KITTITAS COUNTY DEPARTMENT OF PUBLIC WORKS

MEMORANDUM

TO: Kari Braniff, CDS
FROM: Christina Wollman, Planner II *CW*
DATE: August 15, 2008
SUBJECT: Young Administrative Use Permit AU-08-16

17880 Vantage Highway
Ellensburg WA 98926

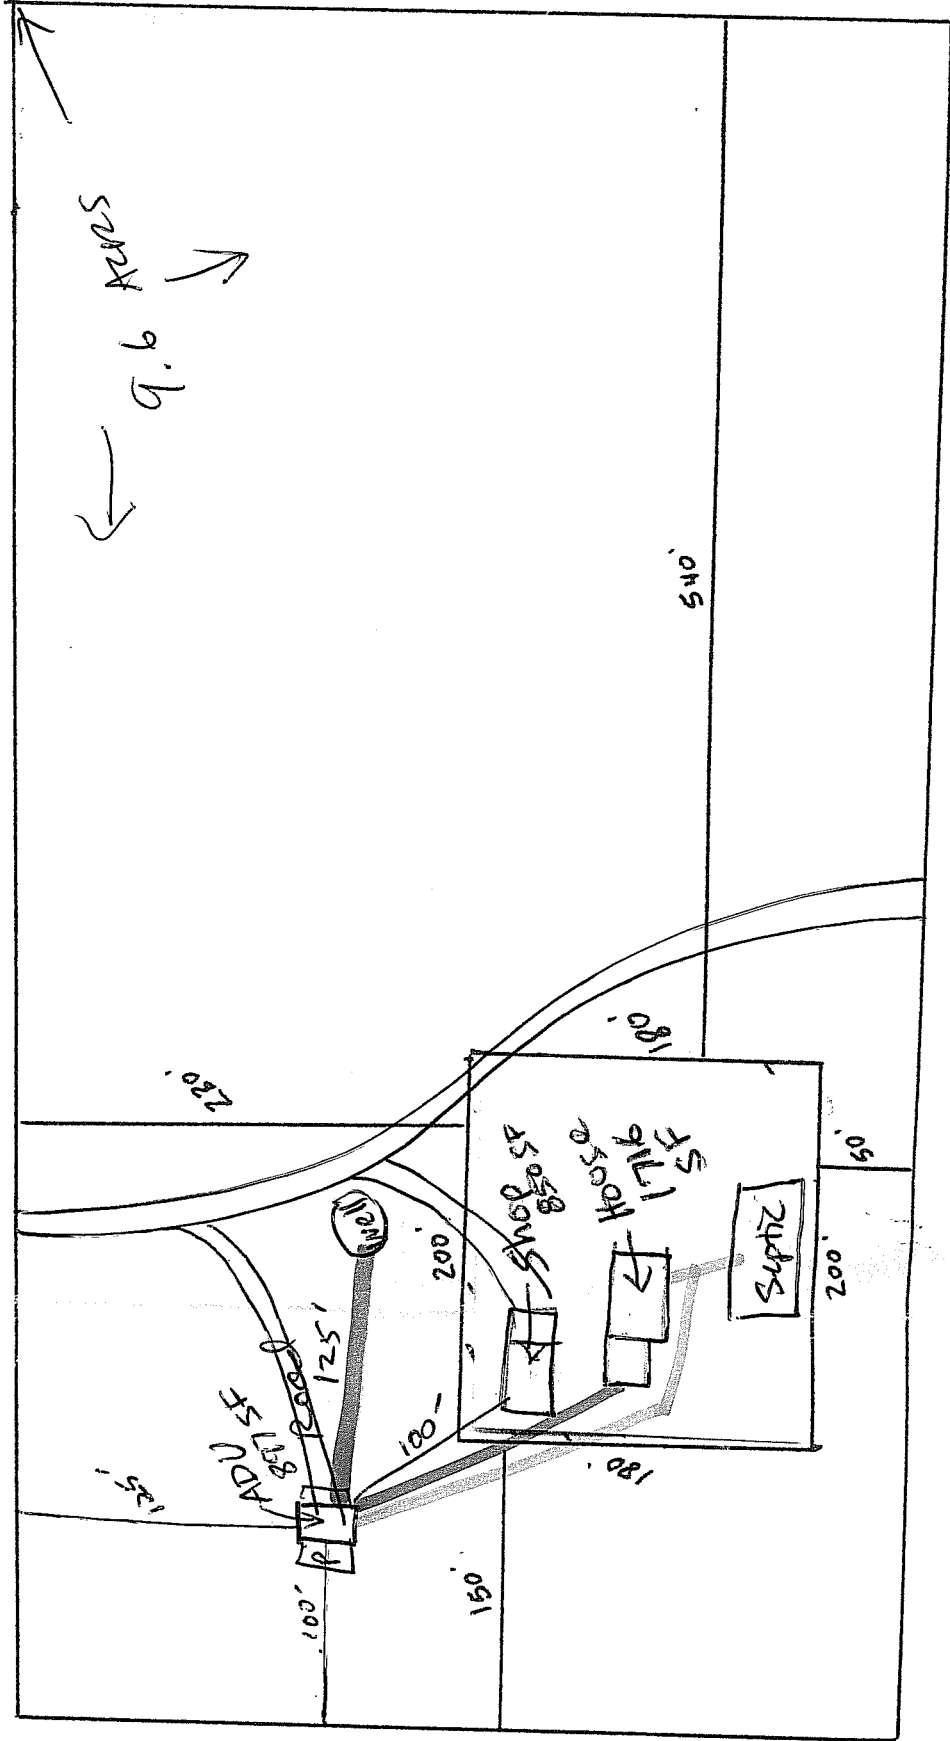
- A. Access: Access to the proposed new residence shall be from the existing driveway at 17880 Vantage Highway. The applicant must adhere to all regulations set forth in the Kittitas County Road Standards.
- B. Access Permit: An approved access permit will be required from the Department of Public Works prior to creating any new driveway access or performing work within the county road right of way.
- C. Addressing: Contact the Kittitas County Rural Addressing Coordinator at (509) 962-7523 to obtain addresses prior to obtaining a building permit. A parcel cannot receive a building permit or utilities until such parcel is identified with a 911 address.
